A428 Black Cat to Caxton Gibbet improvements

9.97 Applicant's Response to the Examining Authority's Third
Round of Written Questions

January 2022

Regulation Number	Rule 8(1)(b)
Planning Inspectorate Scheme Reference	TR010044
Document Reference	TR010044/EXAM/9.97
Author	A428 Black Cat to Caxton Gibbet improvements Project Team, National Highways

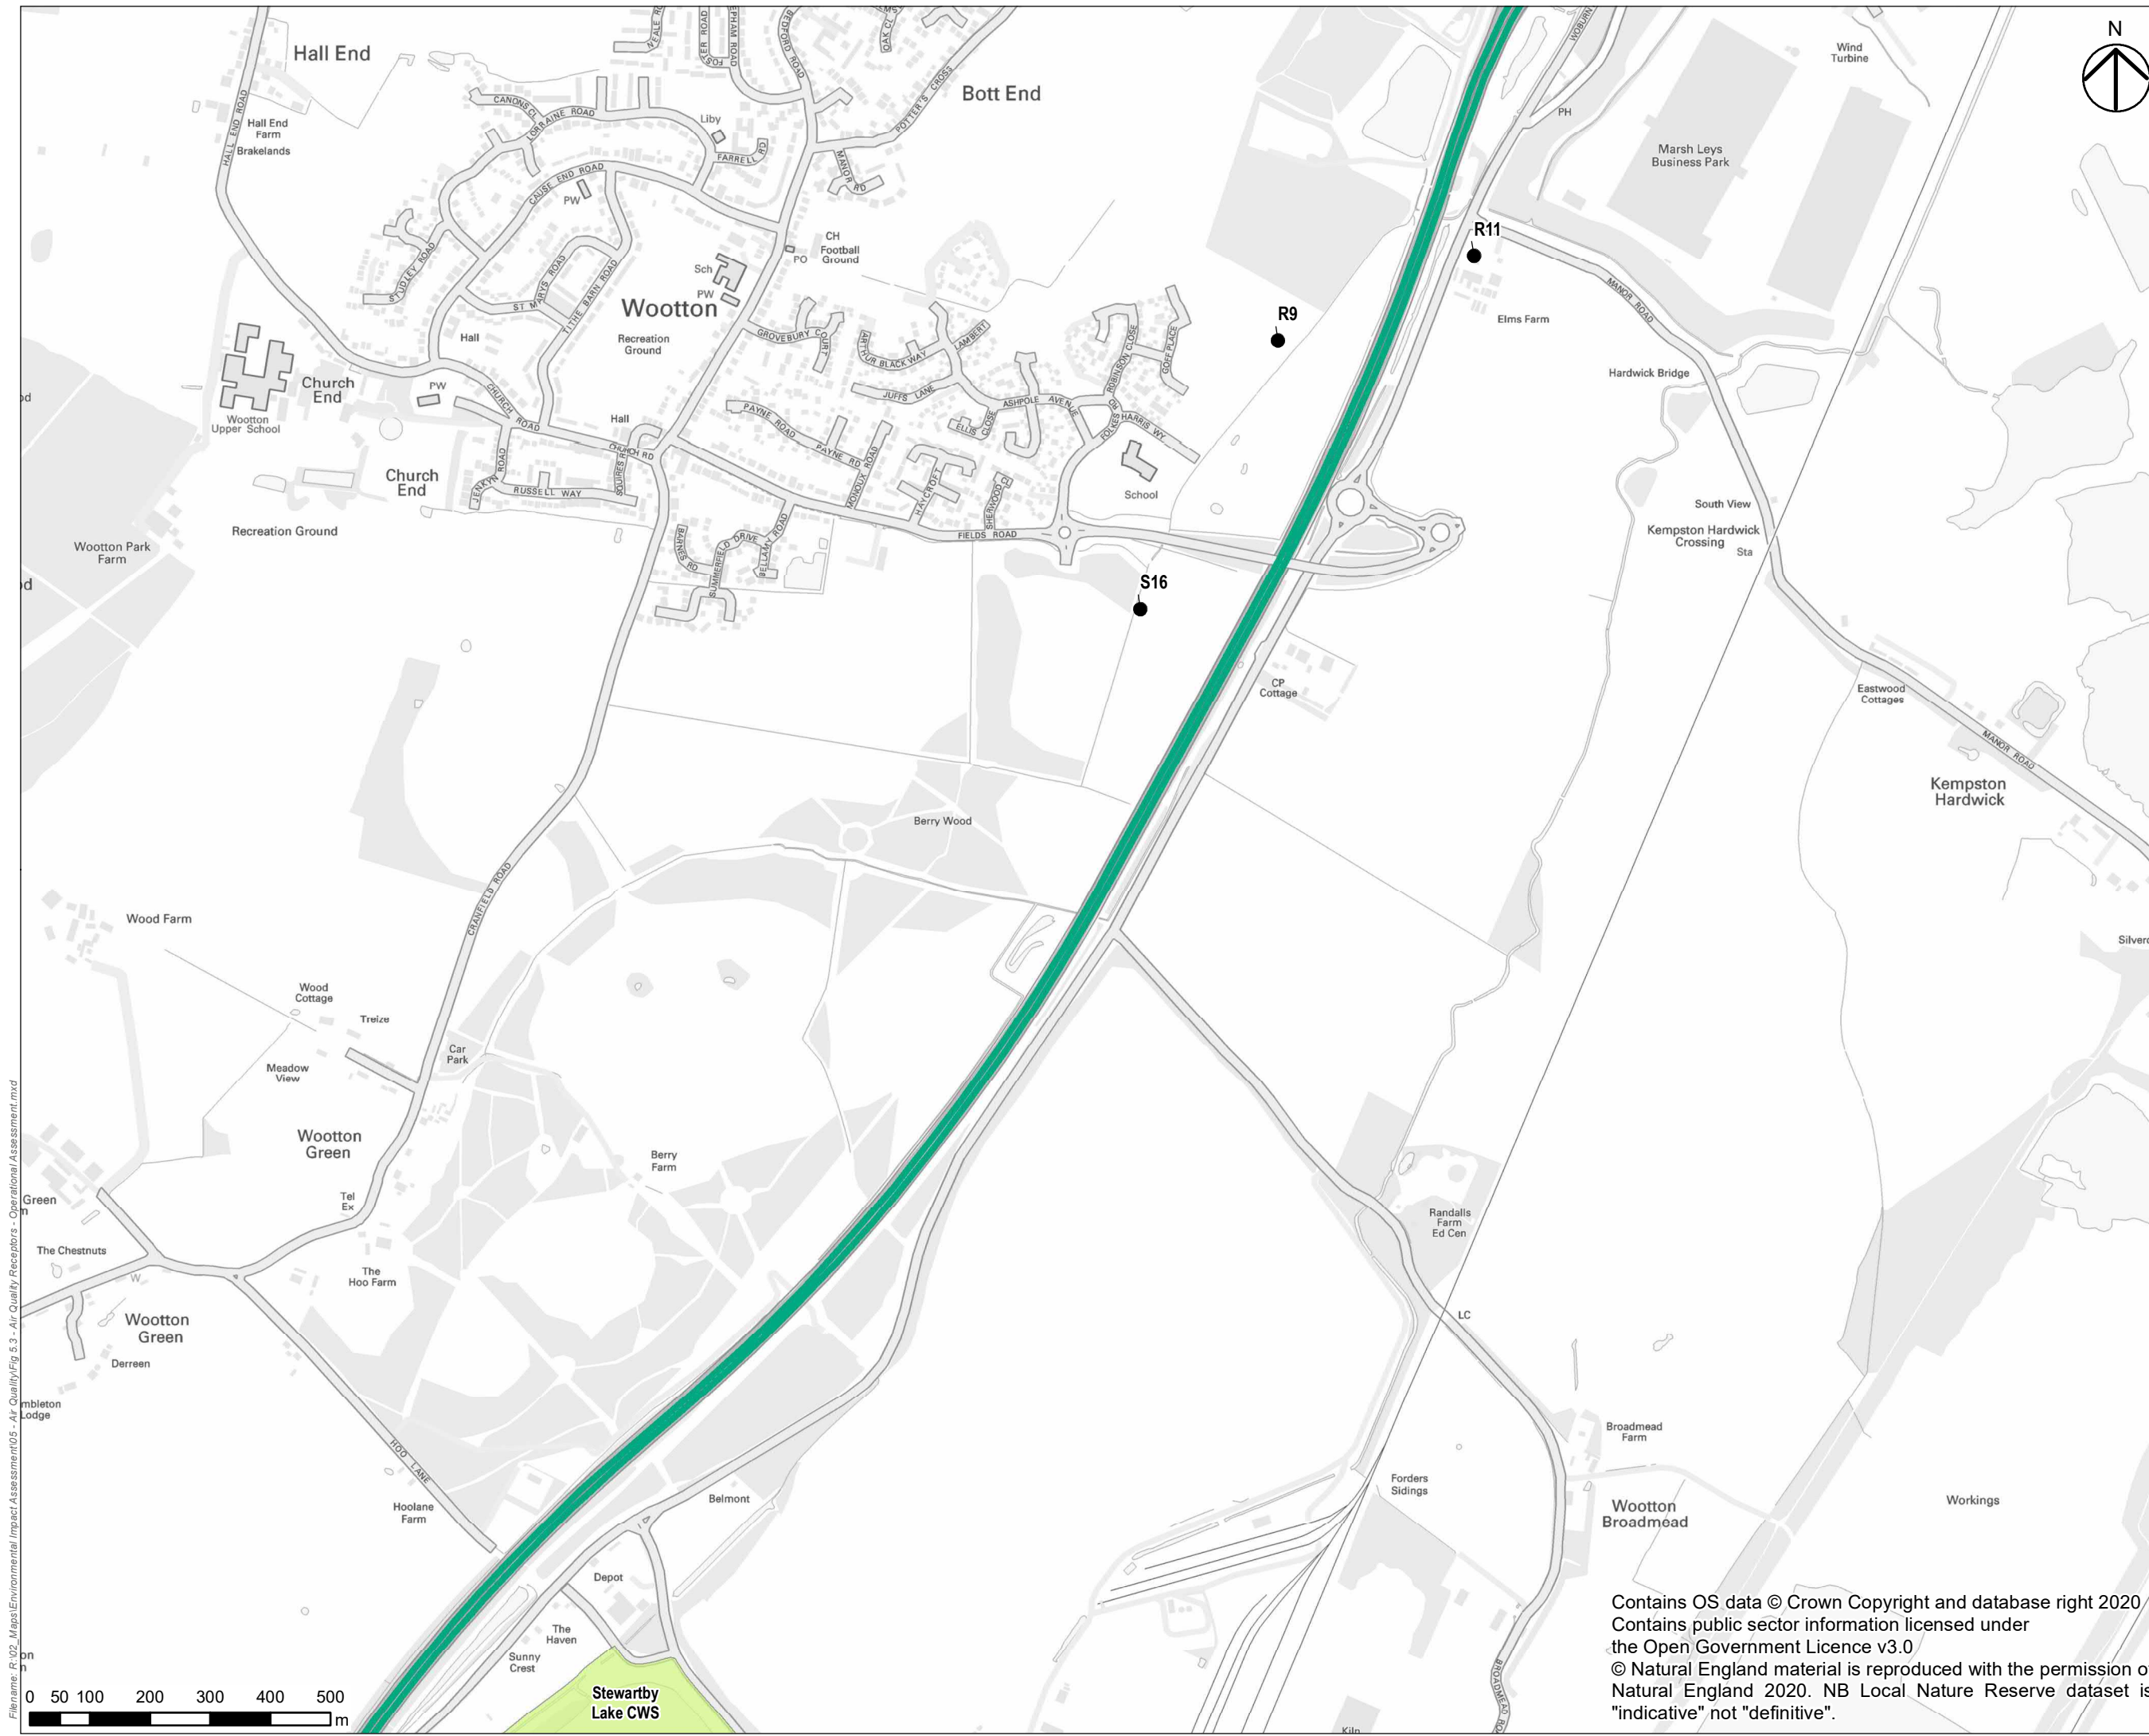
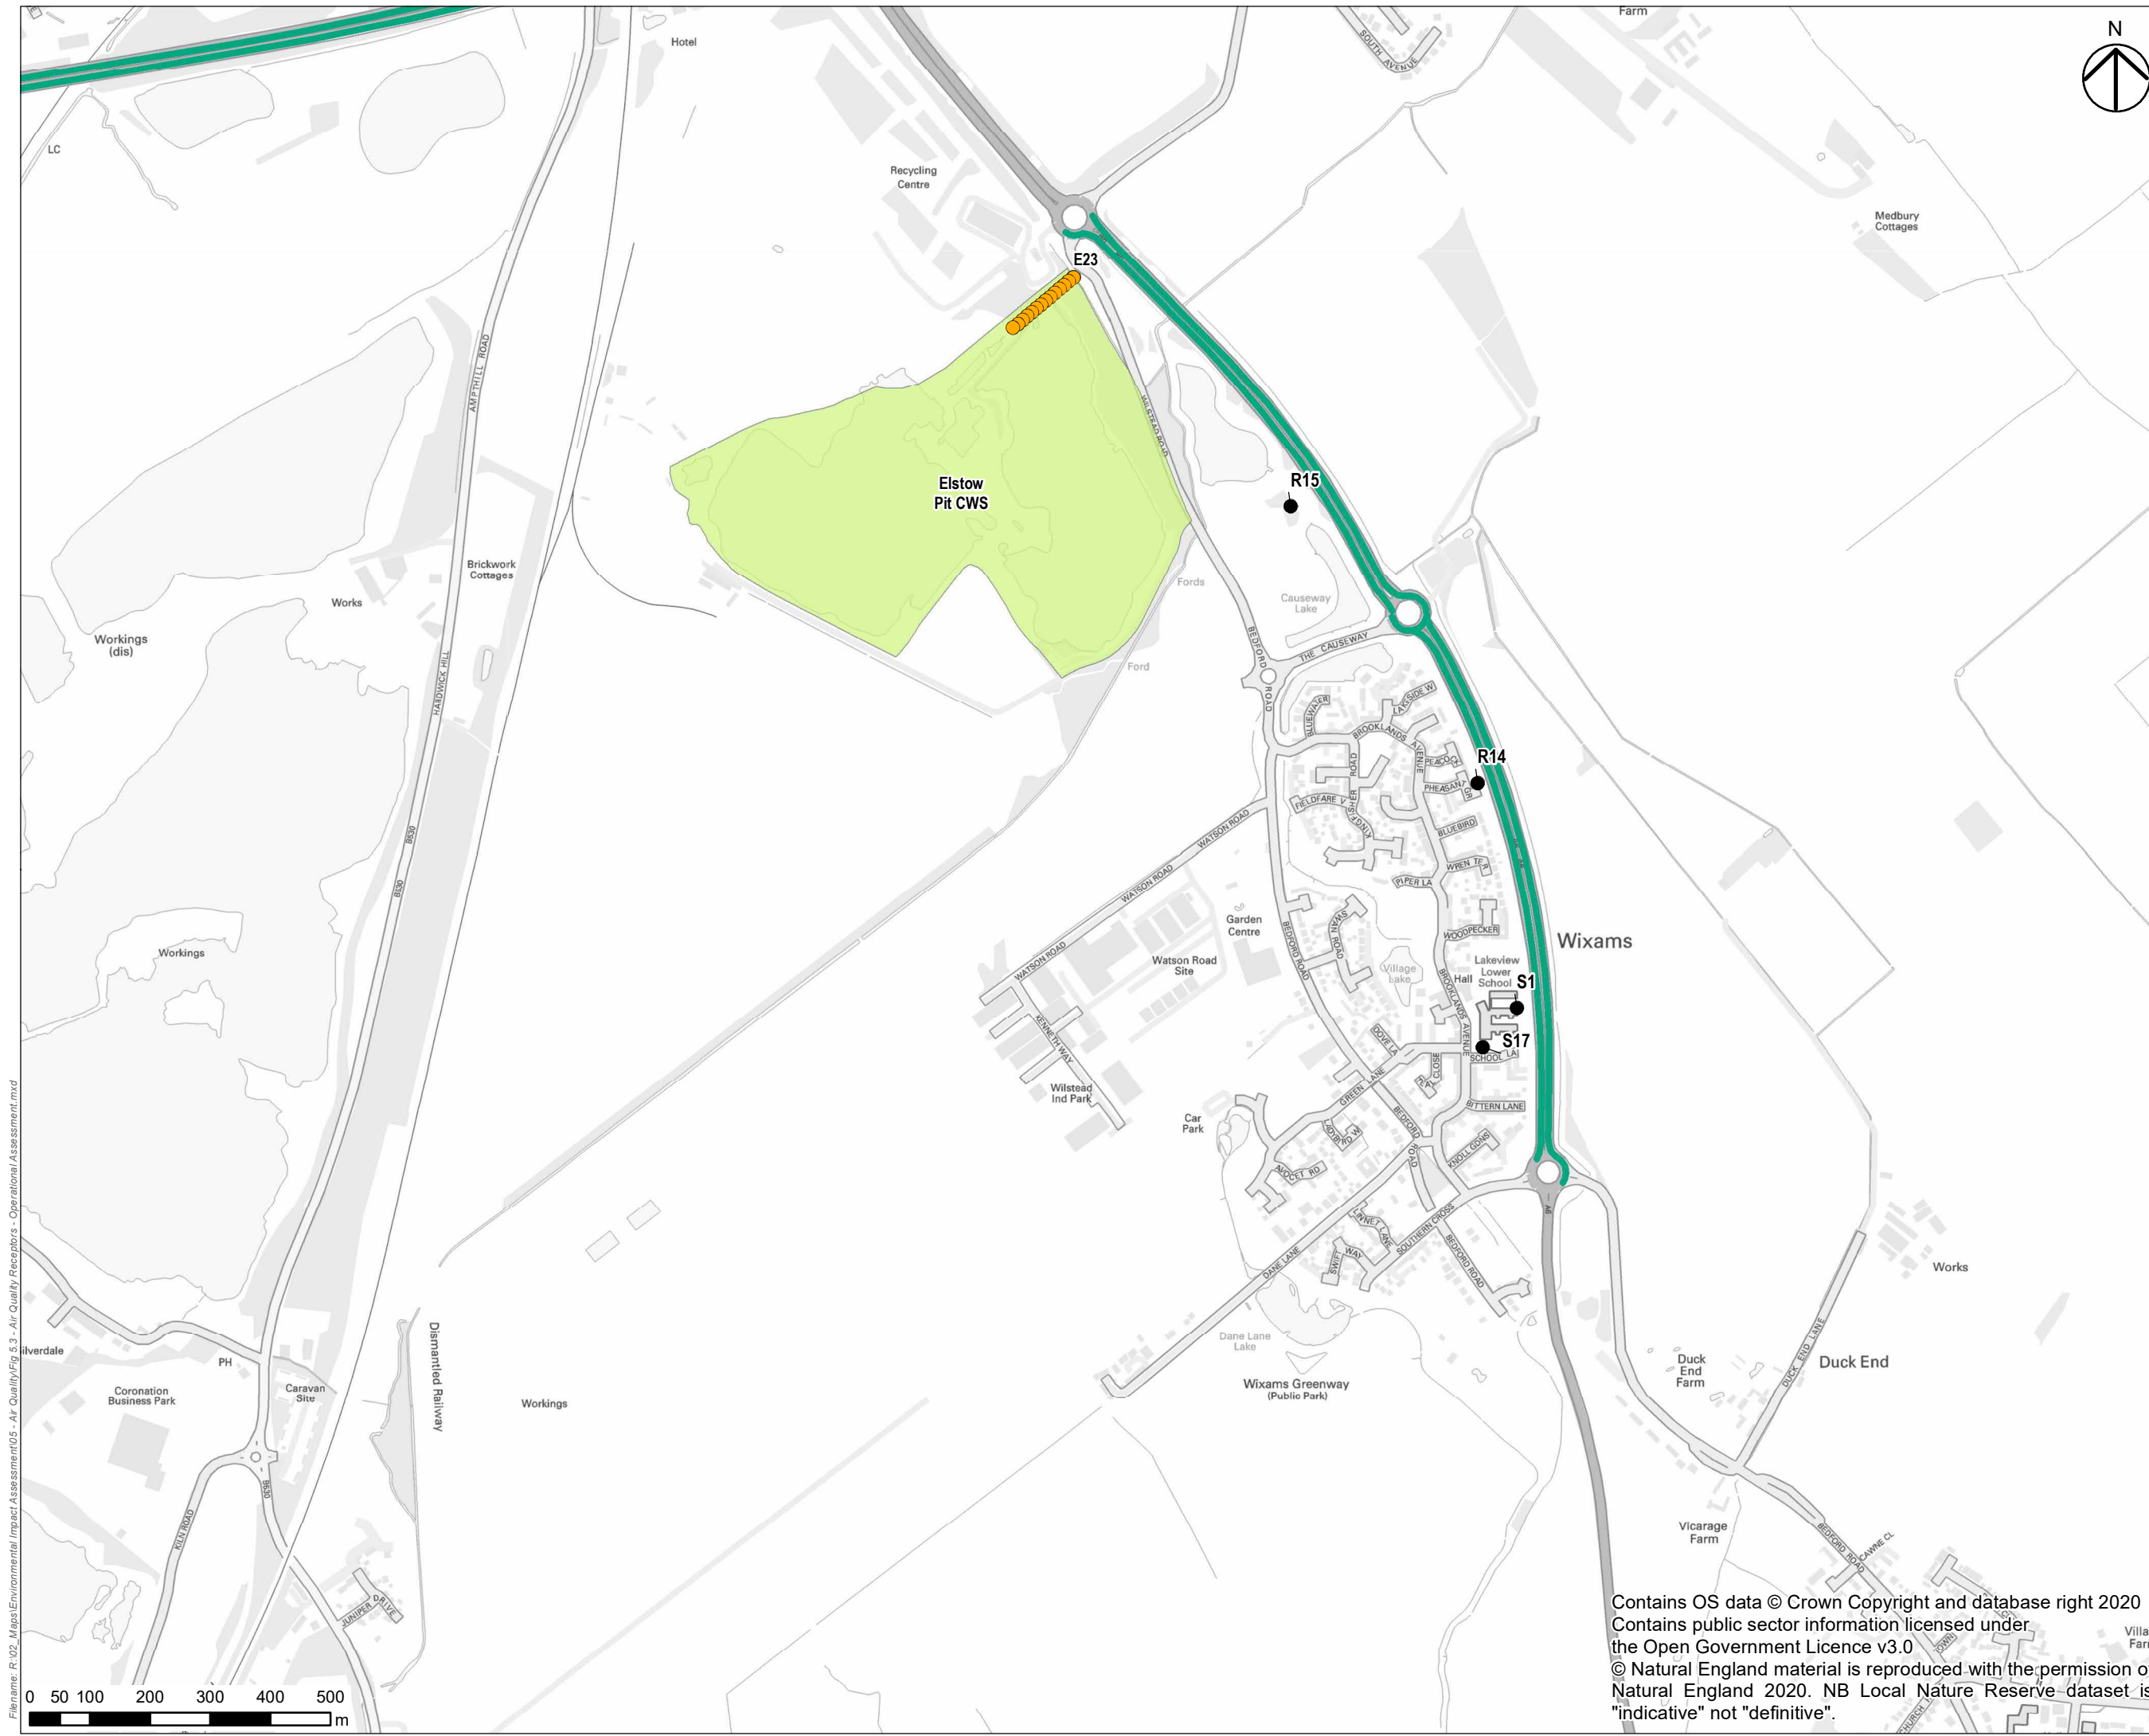
No.	Directed to	Question																							
		<p>As identified above, there are 7 properties within the Sandy AQMA where annual mean concentrations are predicted to be above the objective value for annual mean NO₂ in the Scheme opening year (with and without the Scheme in place). These properties are shown on Figure 5.4 (sheet 9) of the Environmental Statement (ES) [APP-096].</p> <p>To assist the Examination the Applicant has presented in Table 3.2.1.1-1 the highest and lowest predicted annual mean NO₂ concentration which covers the range of concentrations at these properties without (Do-Minimum (DM)) the Scheme and with (Do-Something (DS)) the Scheme. The predicted change is the same at each property. The table presents the predicted concentrations reported in Chapter 5 of the ES [APP-074] and the same data projected to 2026.</p> <p>Table 3.2.1.1-1: Predicted NO₂ Concentrations from the ES and Projected Concentrations</p>

<p data-bbox="654 981 1852 1077"><i>Note: Predicted change is calculated from unrounded predictions. Values rounded to 1 decimal place for presentation.</i></p> <p data-bbox="654 1077 2132 1204">This shows that based on these projections a 1% increase (0.4 µg/m³) is removed within a year with projected reduction in concentrations of between 0.7-0.8 µg/m³ from the opening year to the following year, with the projected Do-Something concentration in 2026 being below the predicted Do-Minimum concentration in 2025.</p> <p data-bbox="654 1204 2132 1284">As a change of this magnitude would be removed within 12 months a significant effect does not arise for the purposes of para 5.12 of the National Policy Statement for National Networks (NPS NN).</p> <p data-bbox="654 1284 2132 1332"><i>CBC Air Quality Action Plan Mitigation Measures</i></p> <p data-bbox="654 1332 2132 1399">CBC have submitted into the Examination their Air Quality Action plan measures [Appendix 7, REP1-055], one of which is the introduction of average speed cameras along the A1 in Sandy AQMA and another was the reduction in</p>	Receptor	2025 (ES Predictions) (µg/m ³)			Projected concentrations 2026 (µg/m ³)		DM	DS	Change	DM	DS	R222	52.5	52.7	+0.2	51.8	52.0	R286	58.0	58.3	+0.2	57.2	57.5
Receptor	2025 (ES Predictions) (µg/m ³)			Projected concentrations 2026 (µg/m ³)																					
	DM	DS	Change	DM	DS																				
R222	52.5	52.7	+0.2	51.8	52.0																				
R286	58.0	58.3	+0.2	57.2	57.5

No.	Directed to	Question
		<p>speed limit to 40mph. In regard to the Sandy AQMA specifically, National Highways have previously discussed possible measures with CBC.</p> <p>The potential for average speed cameras to be installed along this section of the A1 had been initially identified primarily as a potential safety measure and National Highways had given consideration as to whether this might offer any air quality benefits. The consideration of average speed cameras was not put forward as a sole means to deliver air quality benefits rather it would have been explored had the average speed cameras been delivered as part of the safety case. It has now been determined by National Highways that there is not a safety requirement for average speed cameras along this route and National Highways is not aware of any evidence that would suggest the use of average speed cameras here would improve air quality in this location.</p> <p>National Highways commissioned a consultancy firm, Connected Places Catapult to undertake an analysis of changes in emissions from Light Duty Vehicles^[3] (cars and vans) under different driving conditions and different speed limits. The analysis set out in the report demonstrated improvements in NO_x emission rates could be identified when reducing the speed limit from 70mph to 60mph (average approx. 17% reduction in emissions compared to 70mph). No further improvements were identified with a reduction to 50mph (average approx. 15% reduction compared to 70mph).</p> <p>The section of the A1 past the receptors identified in the air quality assessment with annual mean concentration of NO₂ predicted to be above the UK Air Quality Strategy objective of 40µg/m³ already has a speed limit of 50mph. A reduction in speed here to 40mph would not be anticipated to lower vehicle emissions or consequently lead to a reduction in NO₂ concentrations. This is because emissions of pollutants from vehicles vary with speed and the lowest emissions are around 40-60mph, therefore further reductions in speed are not considered likely to improve emissions as very similar emissions are expected around these speeds. This is consistent with the emission rates in Defra's Emissions Factors Toolkit (EFT) and the DMRB speed banding tool.</p> <p>In their response to WQ2, Q2.2.1.1 [REP4-062] CBC refer to studies carried out in other areas that show a permanent speed restriction of 40mph is beneficial for air quality compared to 50mph. The Applicant has requested these studies from CBC (via email 11 Nov 2021) in order to consider the potential for a beneficial effect on Sandy outside of this DCO Examination. This is because the assessment for the Scheme has concluded that it does not trigger a significant air quality effect, as explained above, and therefore mitigation measures are not required. A copy of this study has not been provided by CBC to the Applicant at this time. The Applicant will review these studies once received and seek opportunities to support CBC, potentially through Designated funds.</p>
